VPI Immingham OCGT Project

Document Ref: 7.2
PINS Ref: EN010097

Applicant's Response to Examining Authority's First Written Questions

Applicant: VPI Immingham B Ltd
Date: September 2019

Drawing Title  
**FIGURE 6.1: AIR QUALITY STUDY AREA AND RECEPTOR LOCATIONS**

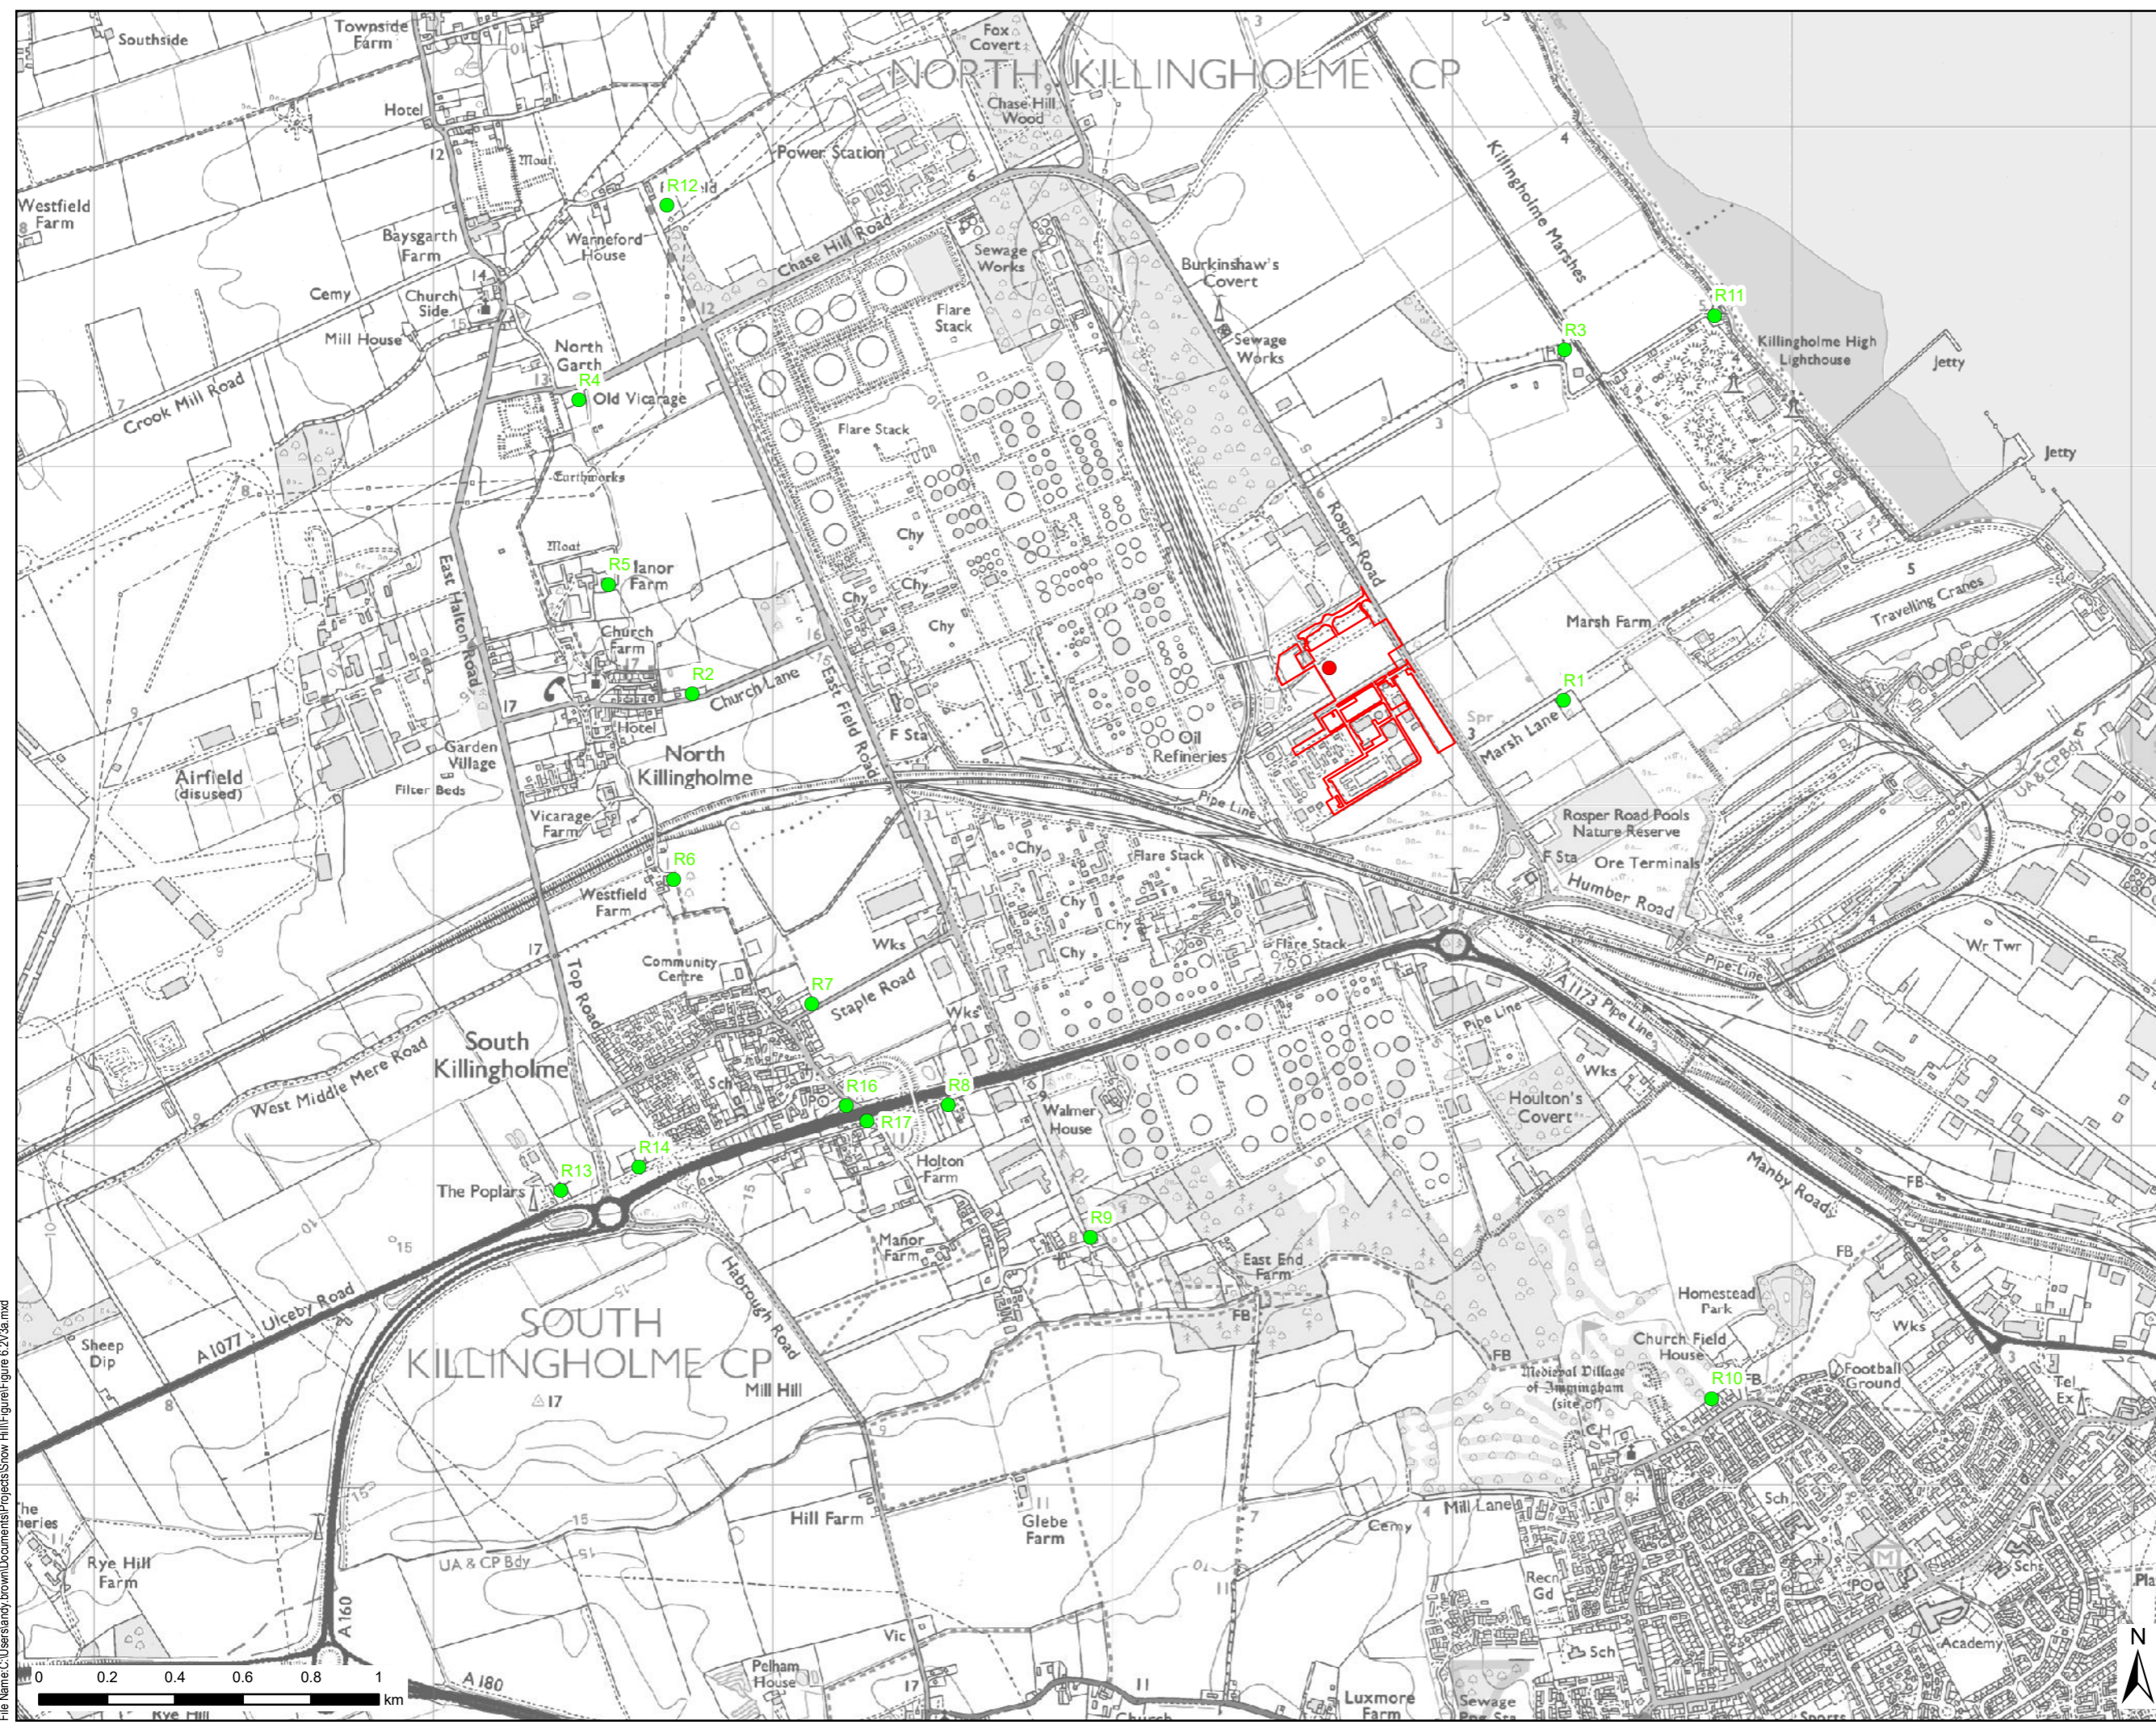
Q1.1.3	<i>Monitoring and receptor locations</i> Applicant	The location of the diffusion tubes and human and ecological receptors used in the assessments are presented on ES Figures 6.1 [APP-056], 6.2 [APP-057] and 6.3 [APP-058]. Can the Applicant provide clarification with regards to these Figures to accurately depict the monitoring and receptor locations?	The references used in the Figures 6.1, 6.2 and 6.3 relate to the receptor and diffusion tube identification numbers provided in the ES Volume I, Chapter 6 Table 6.12 (Receptor Locations) and Tables 6.13 and 6.14 (Monitoring Locations) (Application Document Ref: 6.2.6). Table 6.12 present grid coordinates for the identified sensitive receptors. Figure 6.1 includes the monitoring locations as provided by the Local Planning Authority published information.
Q1.1.4	<i>Confidence of baseline Air Quality Data</i> Applicant	The locations of the NLC automatic NO2 monitoring stations are not depicted on Figure 6.2 [APP-057] and Figure 6.3 [APP-058]. The figures show the monitoring stations and diffusion tubes used to collect baseline data are not distributed throughout the assessment study area. This is not addressed within the Chapter and it is unclear how this data is representative of the entire study area. Can the Applicant explain the confidence it has in the baseline air quality data presented for receptors east of Rosper Road? In responding to this question, The Applicant should address what appears to be an uneven distribution of monitoring locations and the extent to which this affects the findings in relation to NO2 and particulates.	The Defra background maps for the whole study area were reviewed and specifically the concentrations of NO ₂ and PM ₁₀ for the grid squares containing each of the identified receptors (as described in Chapter 6 of the ES (Application Document Ref: 6.2.6, para 6.8.20)) were evaluated. Many of these receptors are located to the east of Rosper Road. The background monitoring data for the Killingholme School monitor is higher than the Defra data for these grid squares, and therefore this higher value was used to provide a conservative assessment of impact on all receptors in the vicinity of the Proposed Development. It is therefore considered that the background data used in the assessment is robust and conservative; lower values based on the Defra mapping could have been used. It can be stated with confidence that using these ambient concentrations leads to a conservative assessment of potential impact. Background Air Quality is dominated by traffic sources, and therefore as the land to the east of the Proposed Development is largely agricultural there are no significant road sources of NO ₂ and PM ₁₀ in this area, and therefore there are no diffusion tube monitoring stations installed by the Local Planning Authority in this area as the area has not been identified to be at risk of exceedance of National Air Quality Strategy objectives. It is therefore considered that the background monitoring data used in the assessment is appropriate and is conservative for the purpose of the assessment. In addition, the magnitude of the change in the annual average pollutant concentrations due to: 1. Construction traffic on the road network due to the Proposed Development; and, 2. The Operational Point Source Emissions is predicted to be imperceptible for all pollutants at all human health receptor locations and ecological receptors, regardless of the background concentration used within the study area.

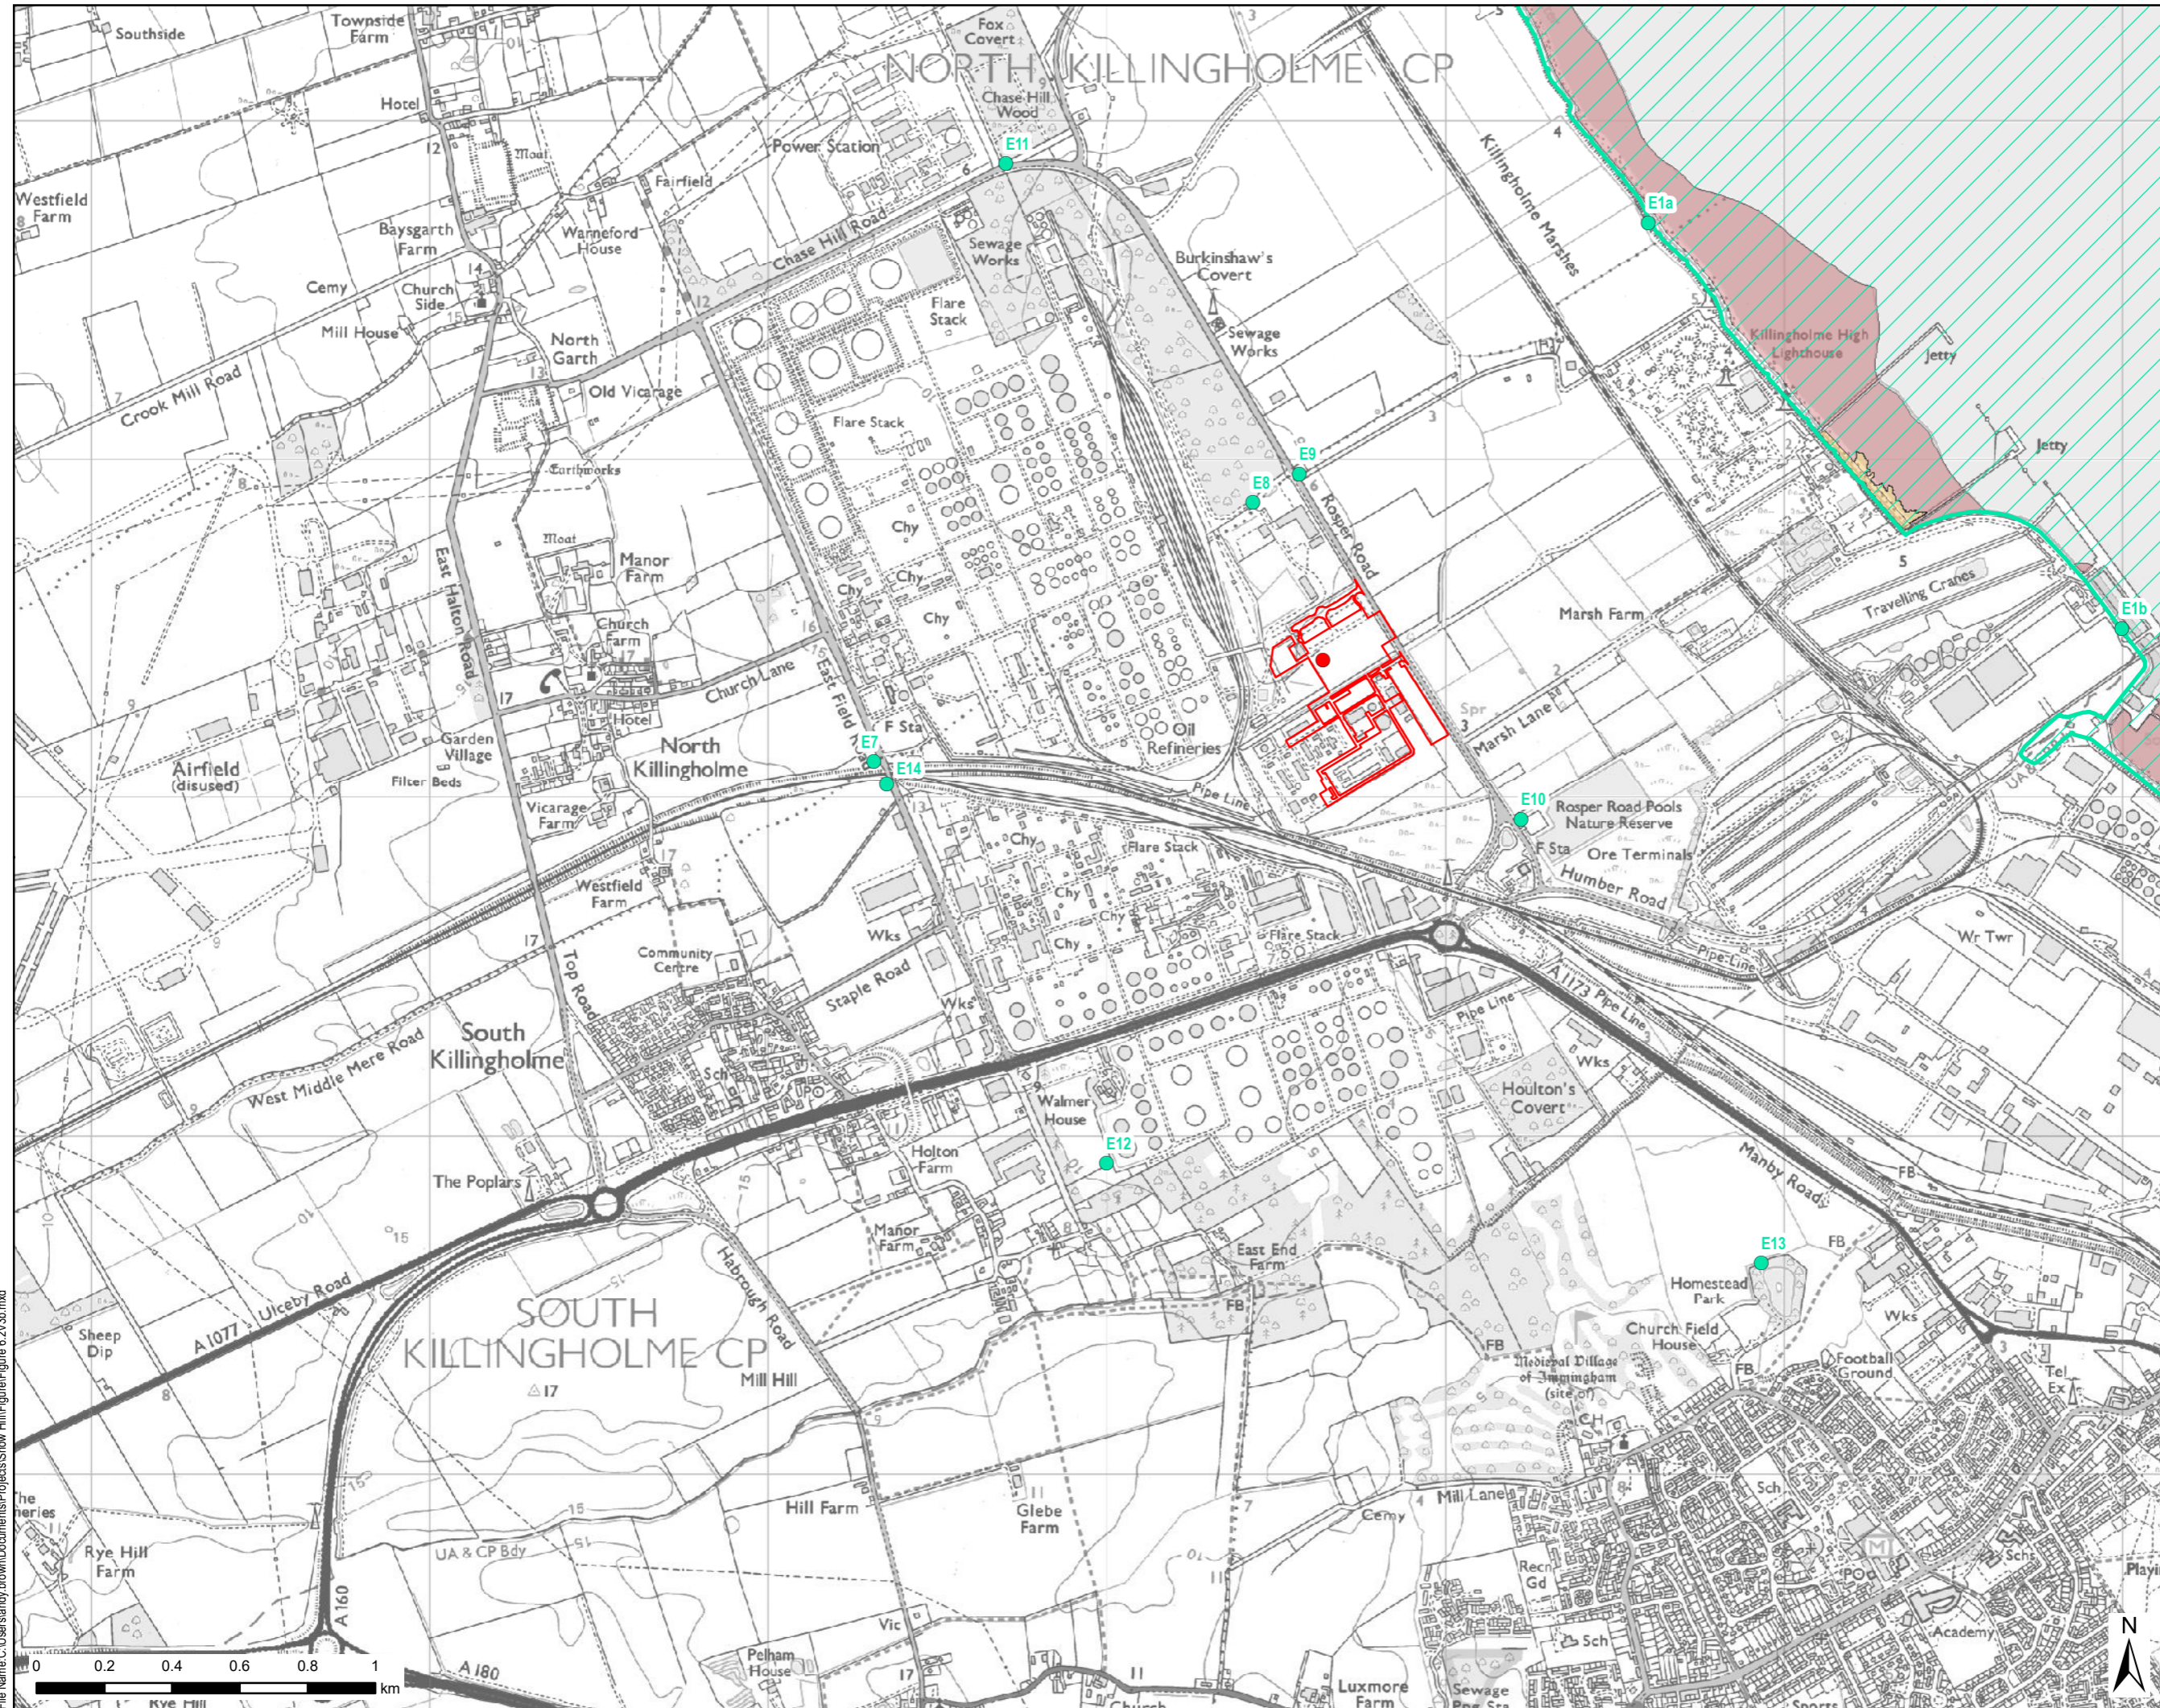
Q1.1.7	Monitoring data Applicant	ES Figure 6.2 [APP-057] and ES Figure 6.3 [APP-058] show that DT15 is the NO2 monitoring station closest to the site, but no reason has been provided for not using the data from DT15 monitoring station. Can the Applicant explain why diffusion tube DT15 and monitoring station DT13 were not used to establish the baseline conditions?	DT13 is considered to be a roadside monitoring location, due to its close proximity to the A160. It is therefore not considered appropriate as a background location for the operational emissions from the Proposed Development. DT15, which although considered to be an Urban Background monitoring site, is still within close proximity to the A160. These monitoring stations are therefore used by the Local Authority to identify and monitor any locations that are at risk of exceeding National Air Quality objectives; they are not intended to be used to derive baseline air quality data for a location on top of which the modelled road contributions from overall traffic flow (including that associated with the Proposed Development) are added. In addition, the area of maximum impact of the operational emissions occurs approximately 2km away from any major road, and therefore it is not considered appropriate to use diffusion tube monitoring data that would be heavily influenced by road emissions as part of the operational impact assessment.
